Our ref: HA/2018/120363/01-L01
Your ref: P/36/18/PL
Date: 10 May 2018

**DEMOLITION & ERECTION OF 1 NO. DWELLING WITH ASSOCIATED VEHICLE
HARD STANDING AREA**

30 LAGOON ROAD PAGHAM PO21 4TJ

PROPOSED SECTION

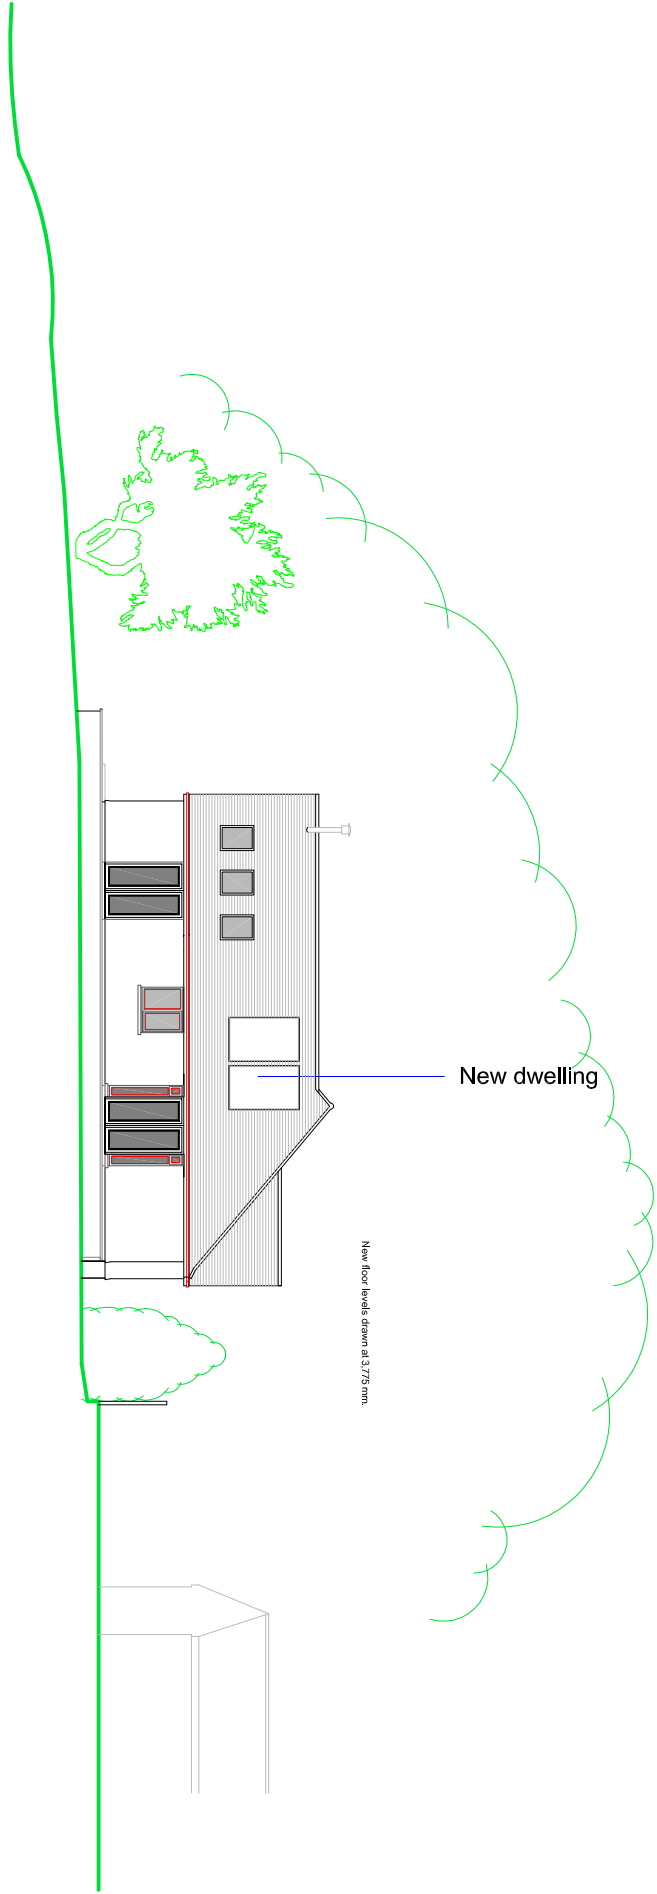
The development permitted by this planning permission shall only be carried out in accordance with the approved Flood Risk Assessment (FRA) (December 2017) and the following mitigation measures detailed within the FRA:

- **Finished floor levels are set no lower than 3.775 metres above Ordnance Datum (AOD).**
